Application No: A/193/20/PL
Site Address: Ham Manor Cottage Ham Manor Way Angmering BN16 4JQ
Description of works: Erection of a 1 No. 3 bedroom chalet bungalow & detached garage. This site is in CiL Zone 3 and is CIL Liable as dwelling.

Thank you for your internet representation made on 15th February 2021 which has been recorded as an objection with the comments as follows:

Proposed Street Scene (Scale 1:200)

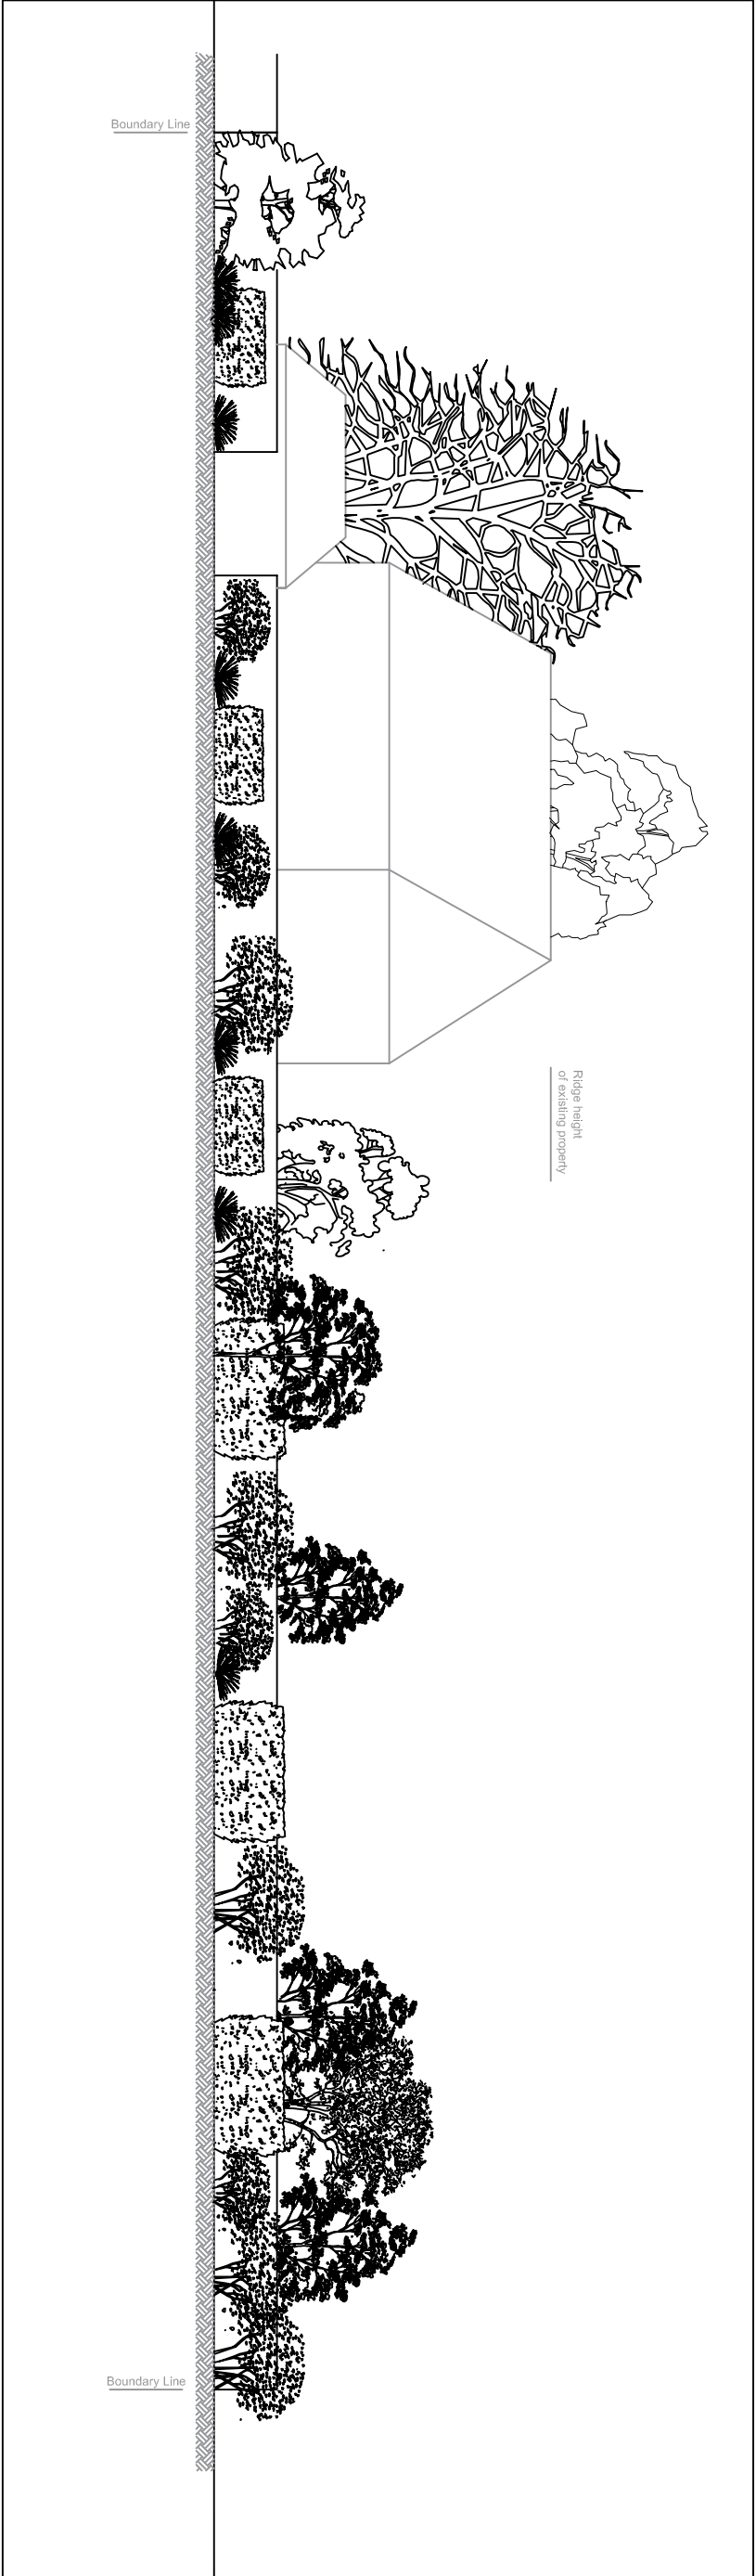
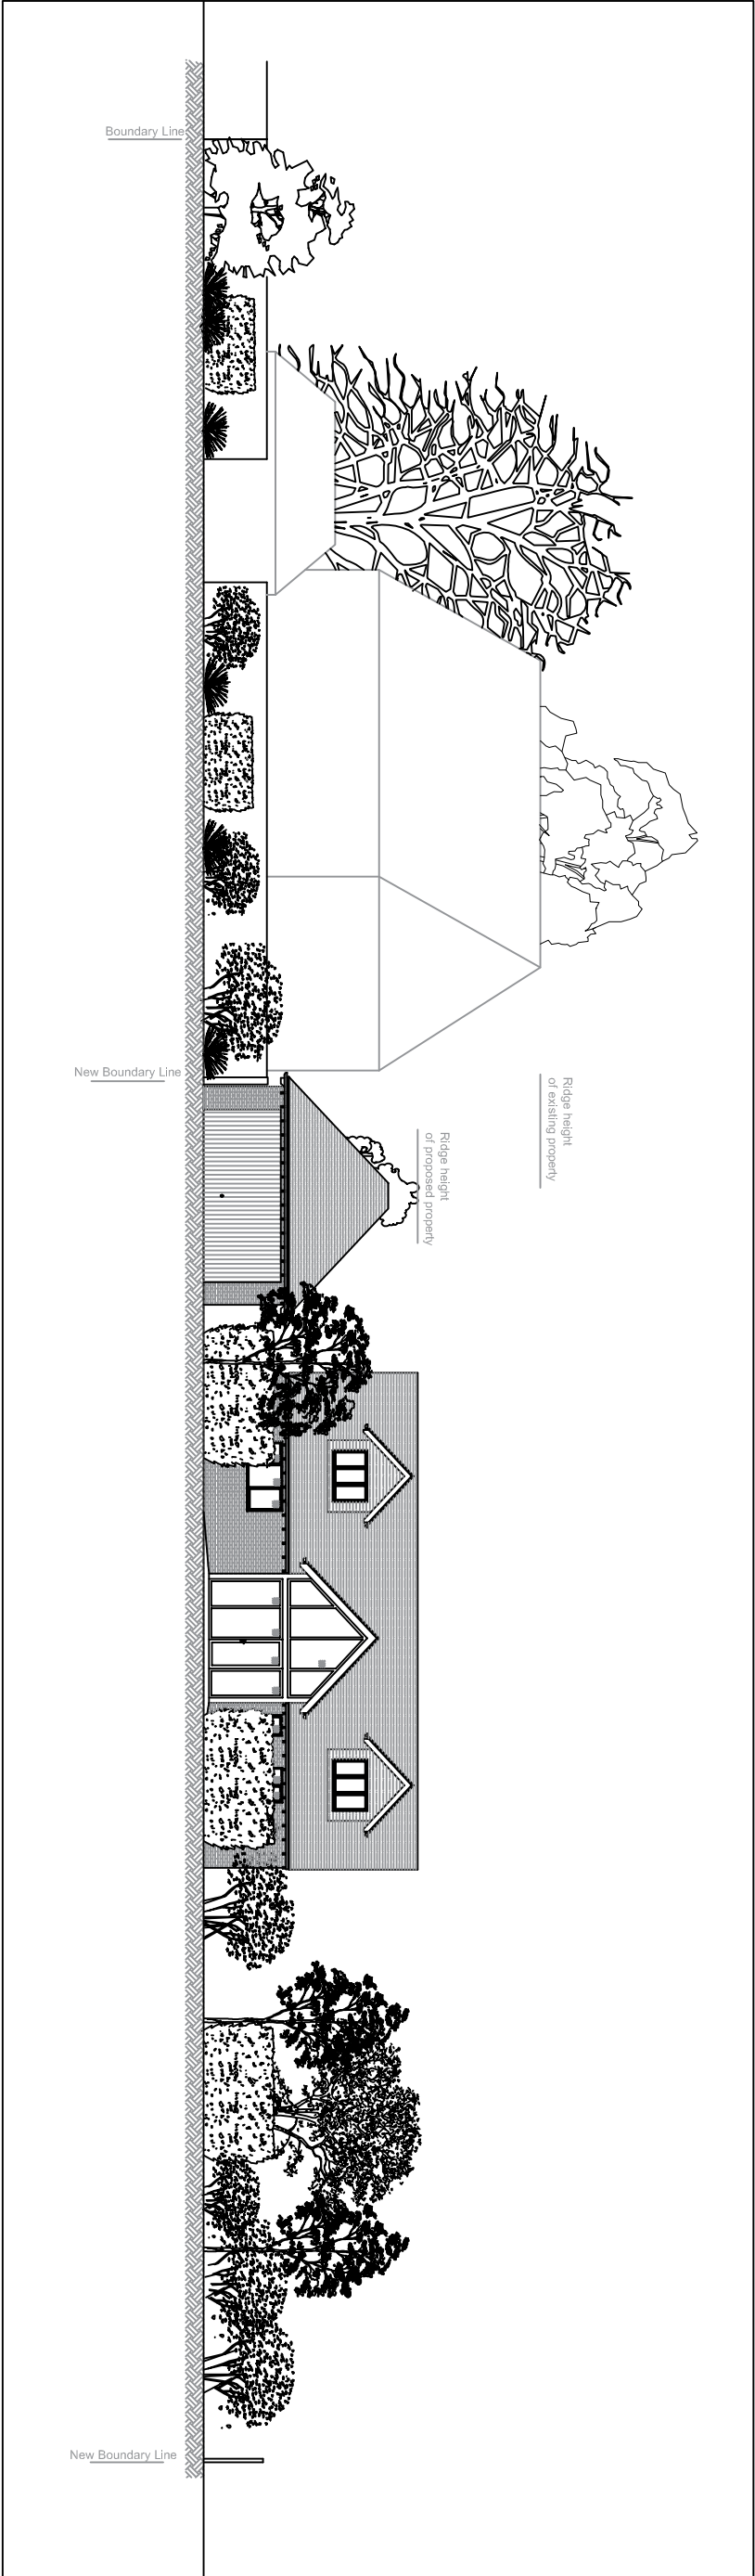
It is claimed no trees or hedges are to be removed. In fact several mature trees have already been removed, presumably in preparation for this application. Also clear from the drawings is that much of the existing small tree and shrubbery planting on the road verge (owned by Ham Manor Golf Club) will have to be removed which will materially alter the street scene.

Revision:	A	Dec 2020	Dimension added
address	Ham Manor Cottage, Ham Manor Way, Worthing, West Sussex		
project	Proposed construction of 3 bedroom detached property with detached double garage		
title	Proposed Block Plan		
scale	date	dwg no.	revision
1:200 on A4		2020.275.02	A

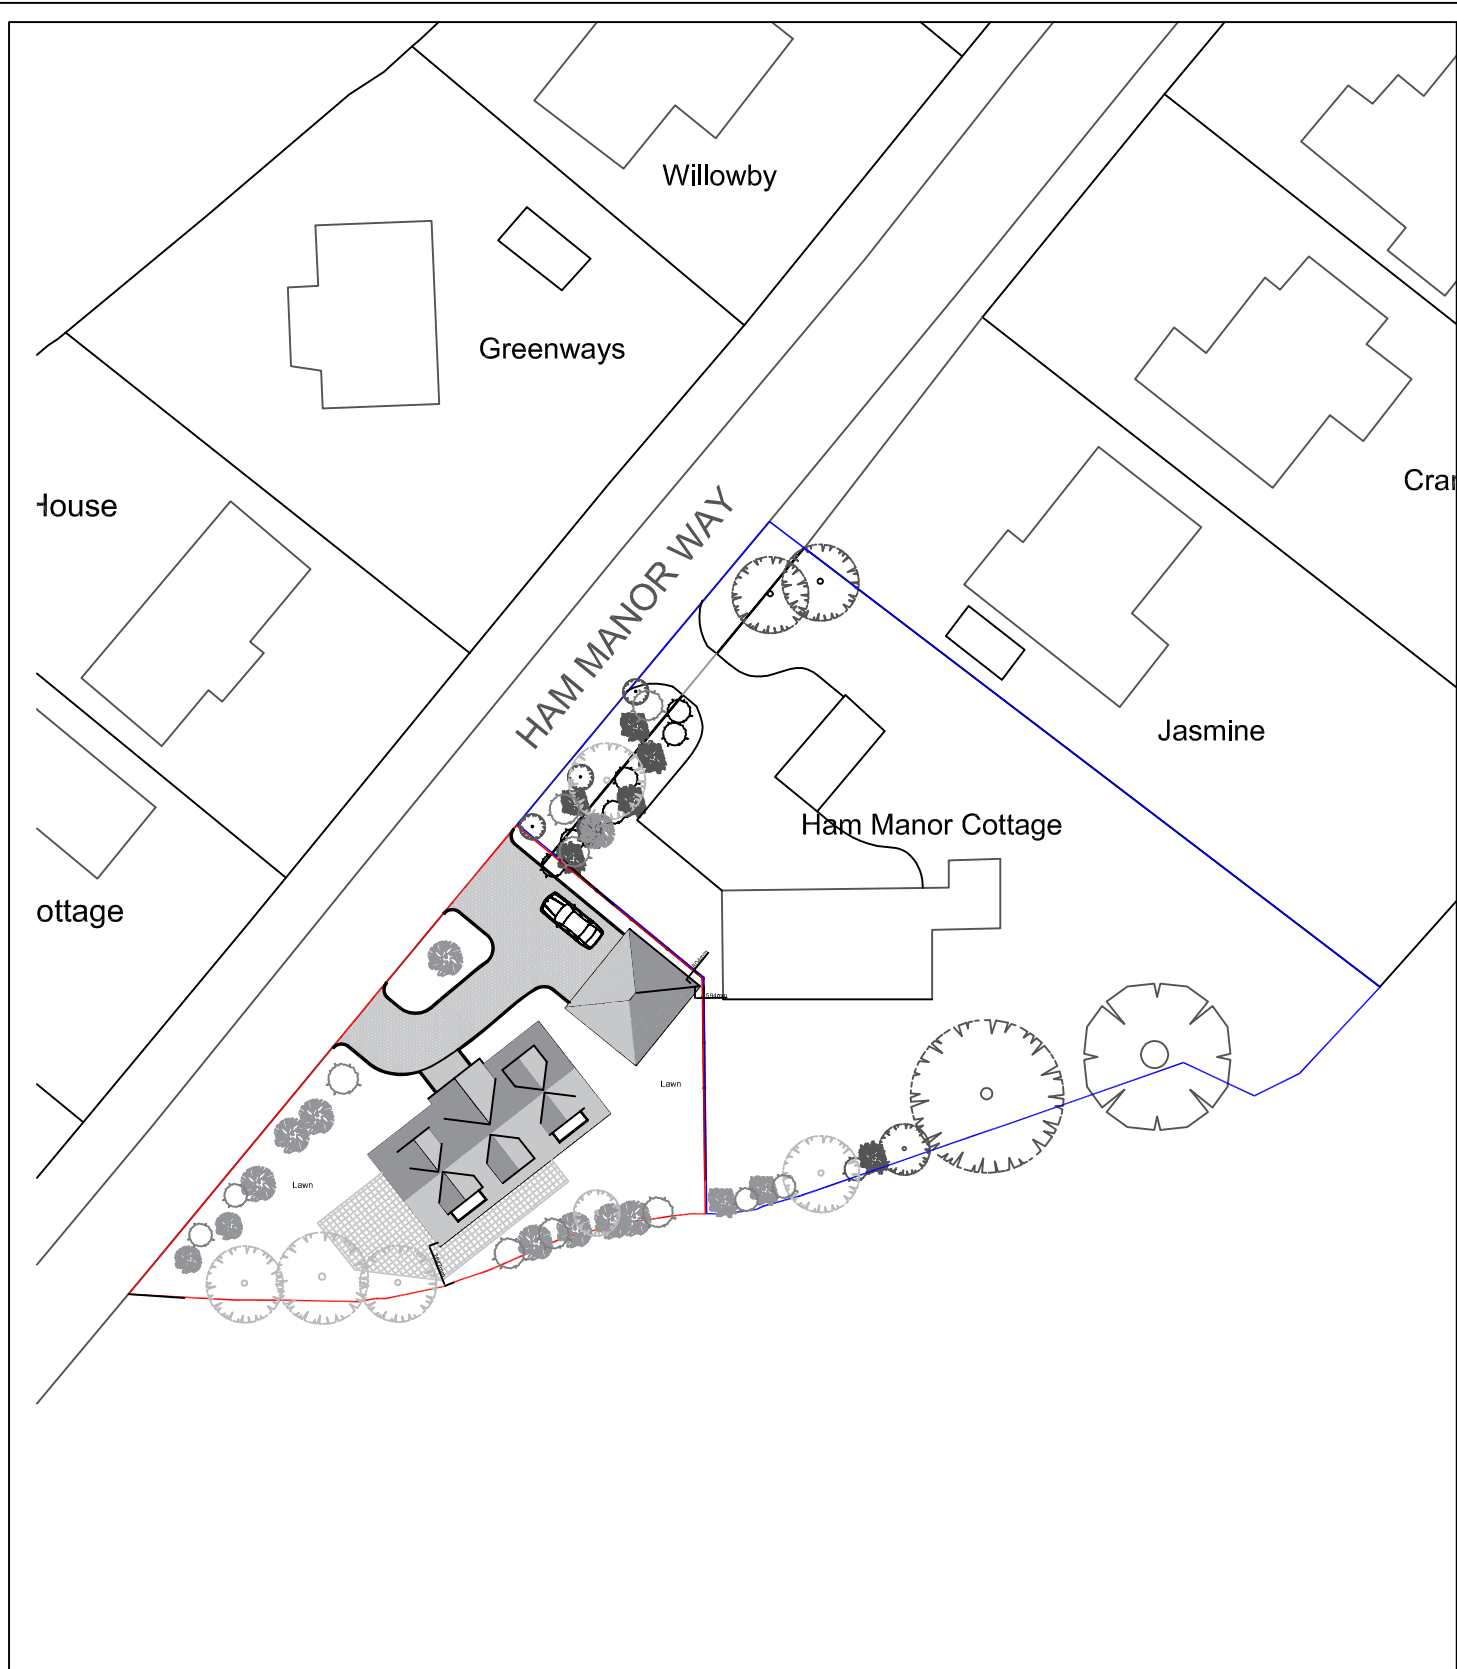
The building also lies in front of the established building line.

The site is of inadequate size, being approximately two thirds of the average plot size on the Estate.

The building is too close to the existing property (which itself has already had two extensions granted) and will materially alter the valued spacious appearance of both it and the Estate in general
